**WEST SUSSEX COUNTY COUNCIL
STRATEGIC PLANNING CONSULTATION**

**SUBJECT: M/18/HH
Vehicular Access – 104 Elmer Road, Bognor Regis**

RECOMMENDATION:

104 ELMER ROAD, PO22 2LJ

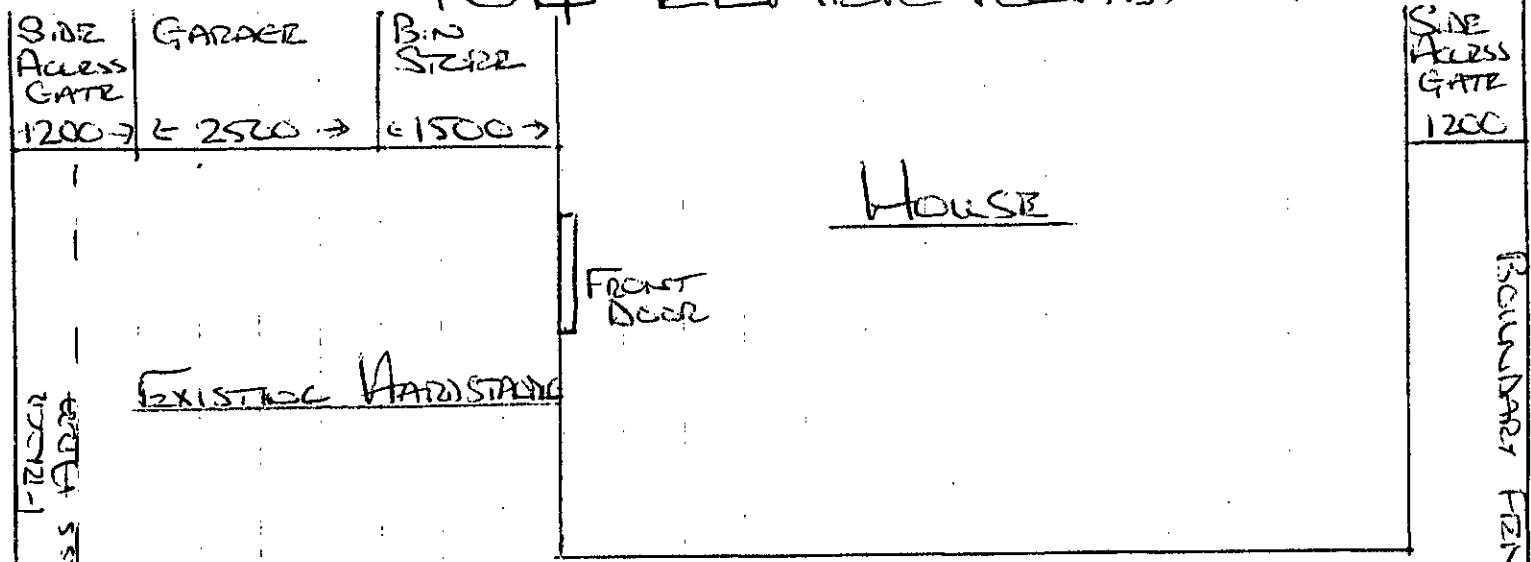
WSSC as the Local Highway Authority raise no objection to the above proposal. Outside 104 Elmer Road the existing pavement terminates. There is already a dropped kerb here and other properties along this road have in and out driveways therefore this proposal would not be out of place. Additionally there are no obstructions in the road to prevent the construction of this. As such the appropriate license may be required to undertake the works; most likely a minor works license and this should be progressed via the Local Area Office.

The applicant is advised to contact the Highway Licensing team (01243 642105) to obtain formal approval from the highway authority to carry out the site access works on the public highway.
